CITY OF ALBUQUERQUE

**RE: Multi-Specialty Clinic
Grading and Drainage Plan
Engineer's Stamp Date 11-20-2015 (File: M15D026B)**

RE: Multi-Specialty Clinic Grading & Drainage (File M15-D026B)

JOEL D. HERNANDEZ P.E. #17893	MULTI-SPECIALTY CLINIC 2901 TRANSPORT ST, S.E. GRADING AND DRAINAGE PLAN TIERRA WEST, LLC 5571 MIDWAY PARK PLACE NE ALBUQUERQUE, NM 87109 (505) 858-3100 www.tierrawestllc.com	DRAWN BY DY	
		DATE 11/06/15	
		2015044-GRB	
		SHEET # GR-2	JOB # 2015044

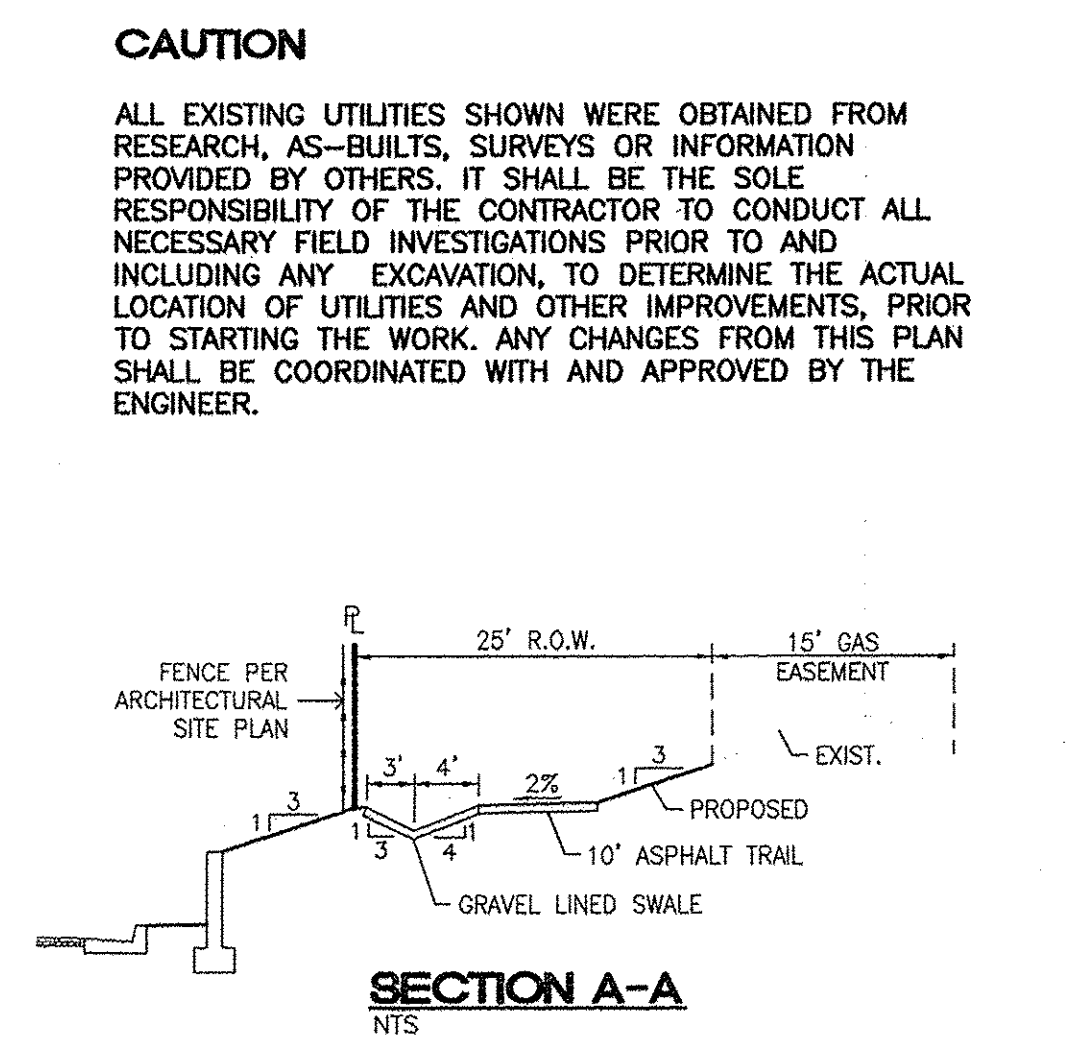
2. Sheet RW-1 shows a back of wall profile that has a 2-foot drop, which implies that, the trail profile would have the drop as well.

7. Include a cross section of the bike trail to show the intended cross slope to ensure positive drainage from the wall.

Response: We have revised the location of the bike trail to be within the trail right of way and adjusted the retaining wall location such that the trail elevation is unaffected by the retaining profile. Please see the typical section added to Sheet GR-2 which depicts the relationship between the wall and trail.

Response: We have added a typical section detail to Sheet GR-2 which depicts the relationship between the wall and trail.

ENGINEER'S SEAL  JOEL D. HERNANDEZ P.E. #17893	MULTI-SPECIALTY CLINIC 2901 TRANSPORT ST, S.E. GRADING AND DRAINAGE PLAN	DRAWN BY DY
		DATE 11/06/15
	TIERRA WEST, LLC 5571 MIDWAY PARK PLACE NE ALBUQUERQUE, NM 87109 (505) 856-3100 www.tierrawestllc.com	2015044-GRB
		SHEET # GR-4 JOB # 2015044

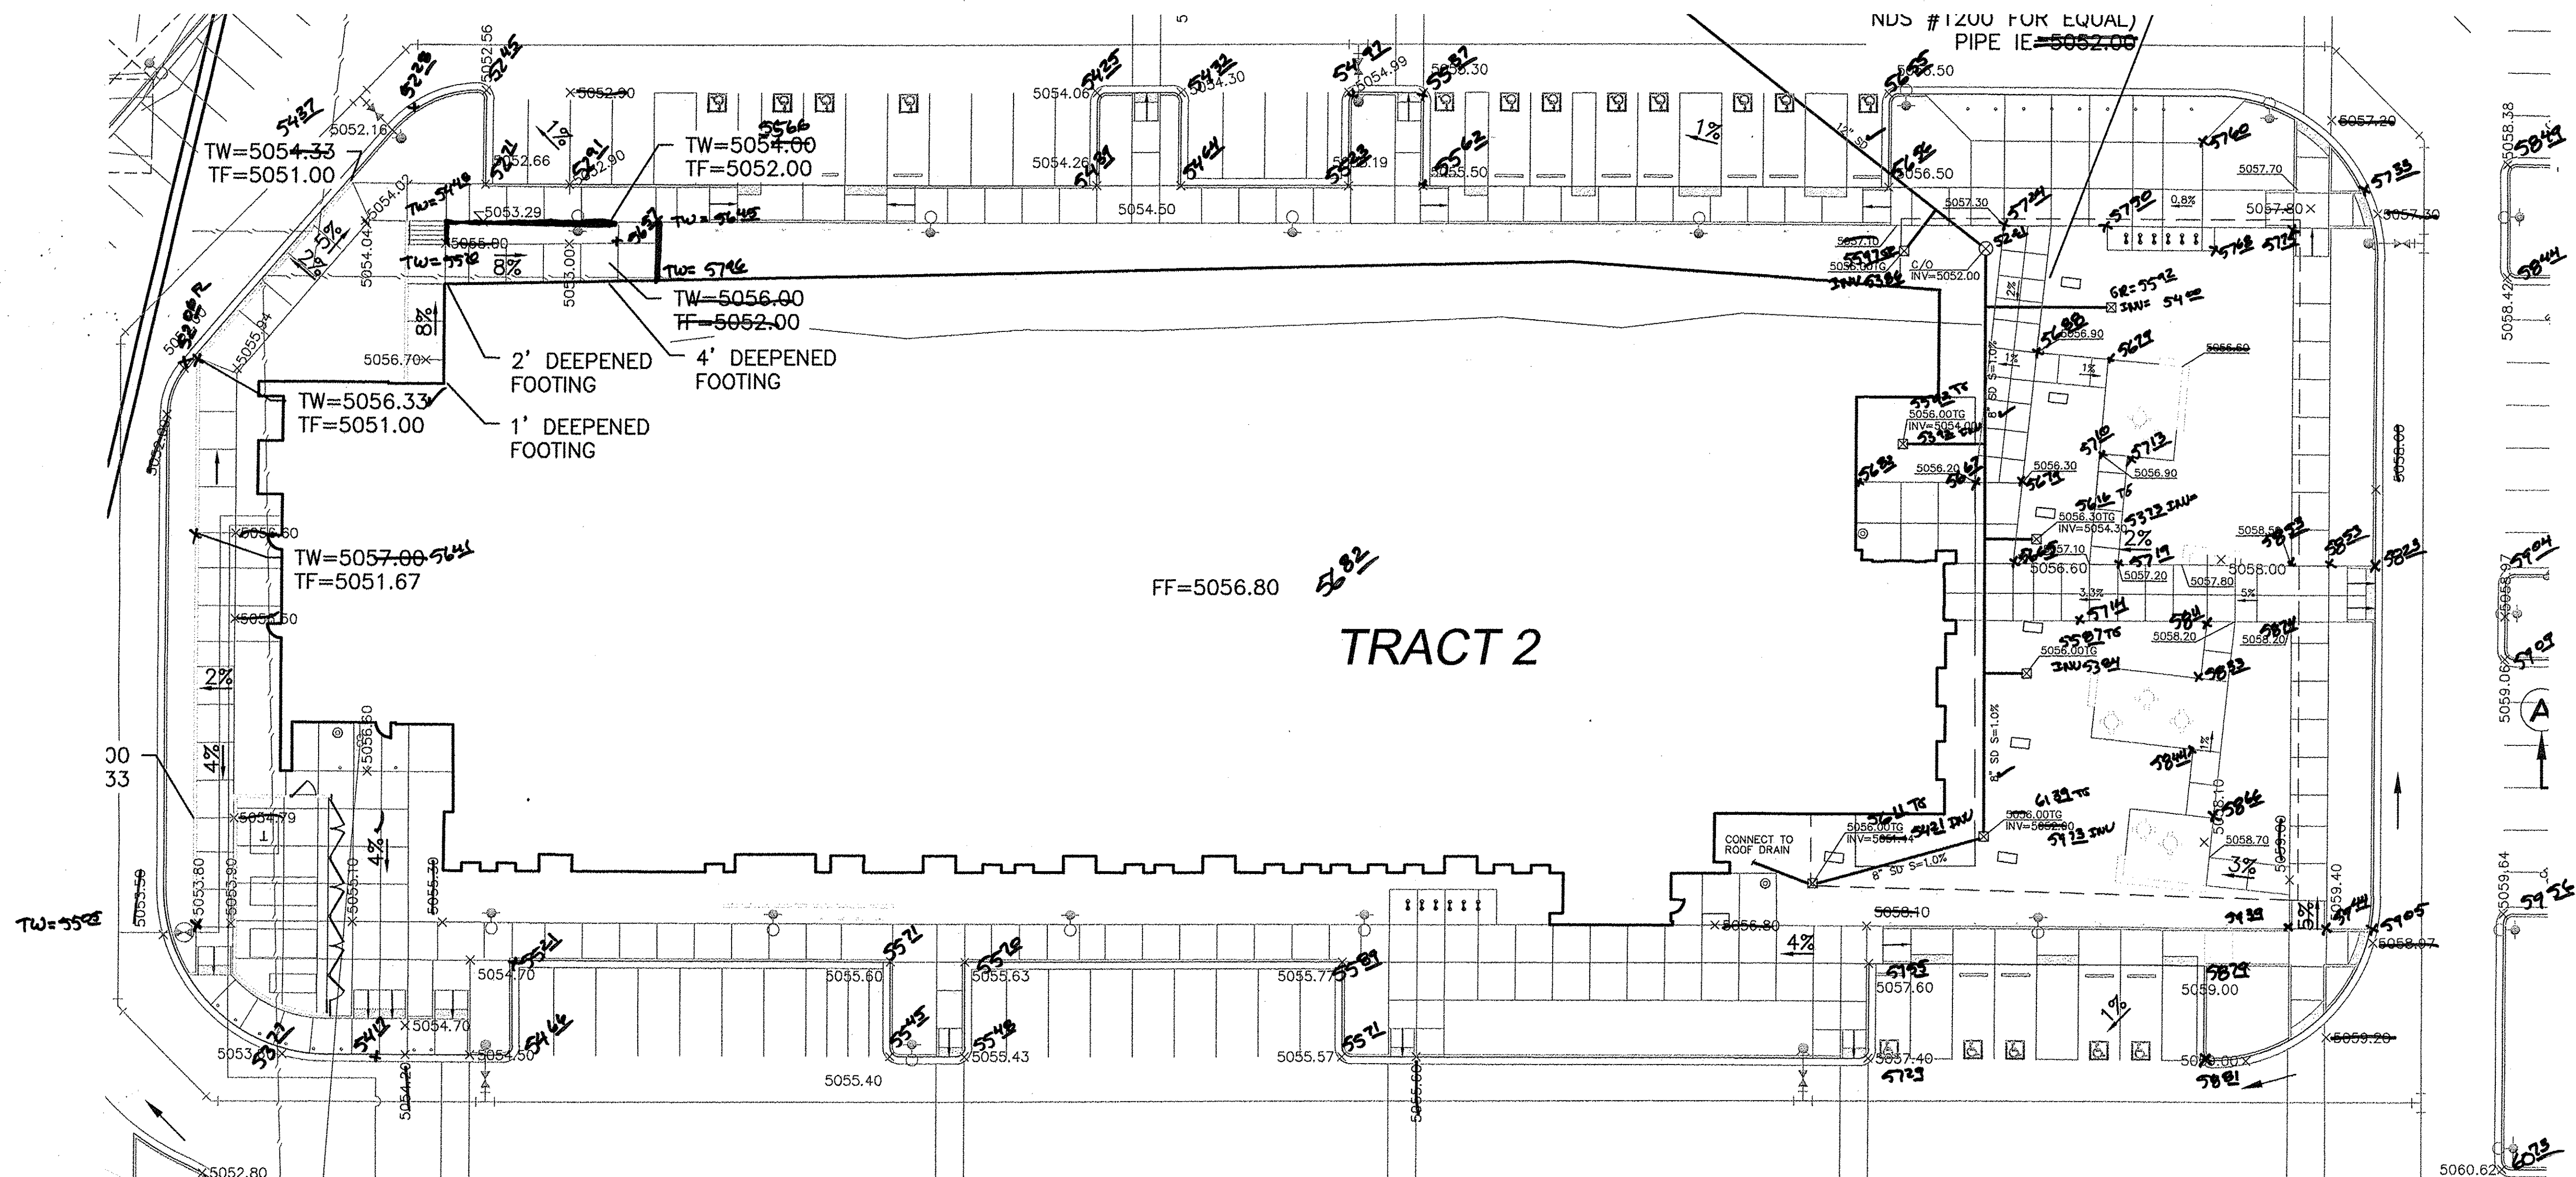
6. Ensure that all ADA ramps are shown on both the Site Plan and the Grading Plan Sheets.

Response: We are including the Horizontal Control Plan/Paving Plan (Sheet C1) which also depicts the ADA ramps, as well as plan sheet (Sheet GR-4) at 1"=20' to more clearly show the ADA access in the flatwork around the building.

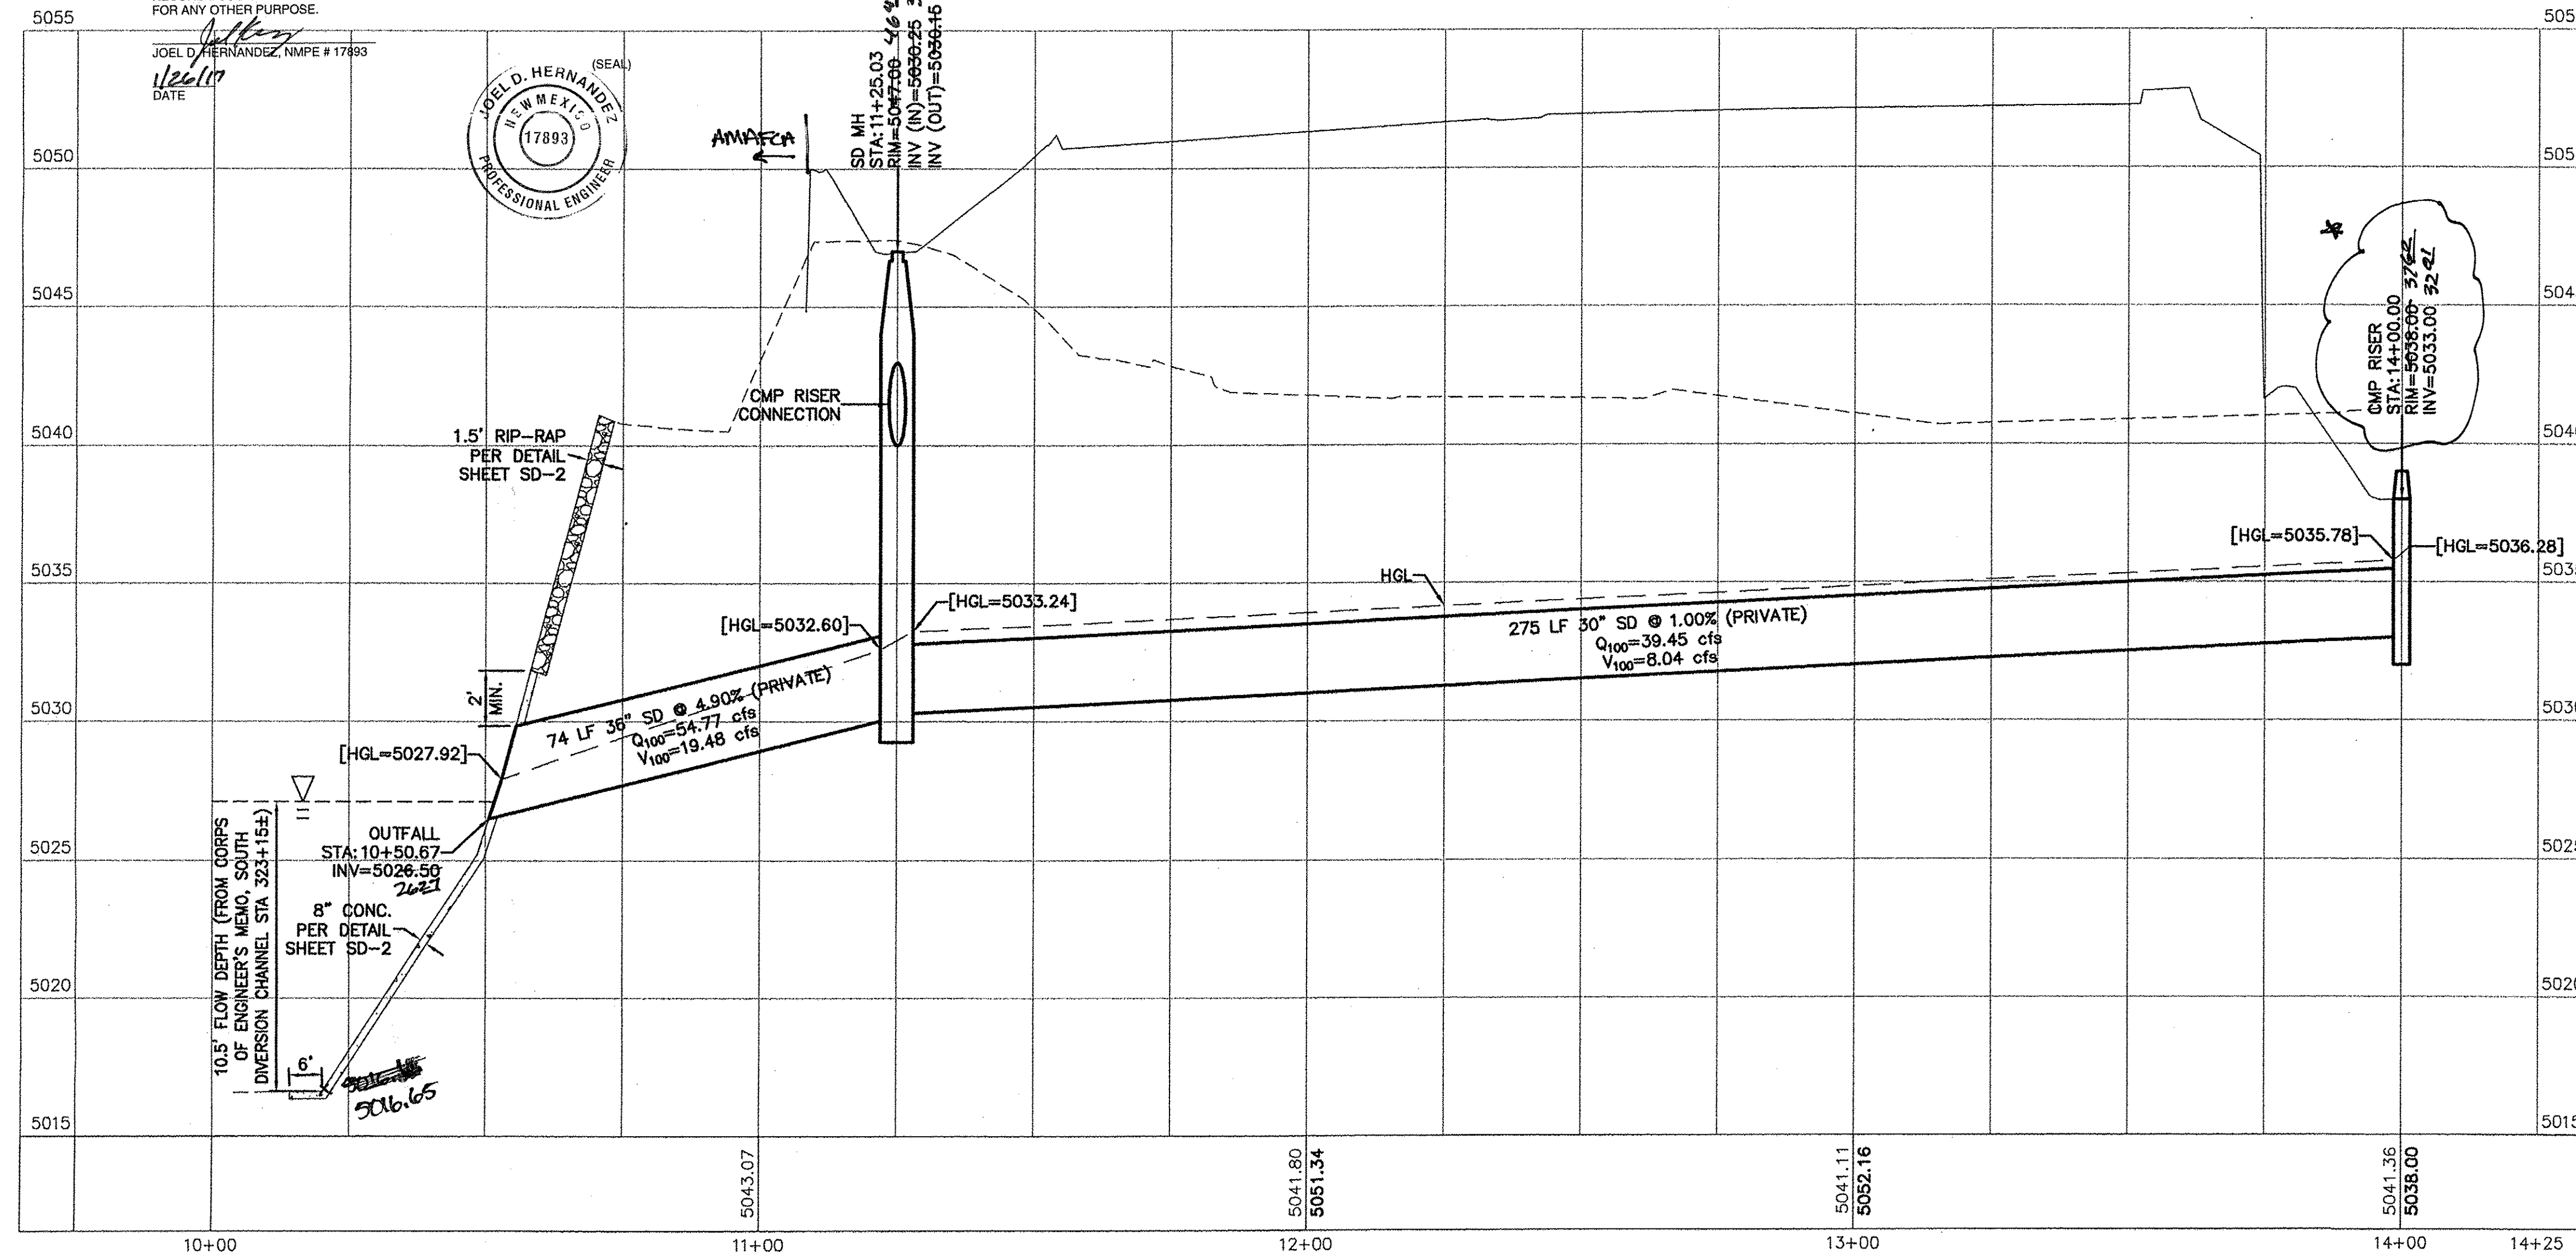
11. Has coordination with the USACE been completed per AMAFCA's review letter of the Capstone Student Housing Drainage Management Plan (letter dated June 25, 2013)?

Response: The review with the USACE is ongoing, but is limited to the construction of the outfall improvements. We have added a note to the storm drain plan (SD-1) requiring this work proceed upon and until approval is obtained from the USACE and authorization from AMAFCA. The work within the AMAFCA right of way is subject to executed license agreement which requires adherence to the approved plans and notification of the AMAFCA Project Manager at least forty-eight (48) hours prior to beginning work on or in the AMAFCA property.
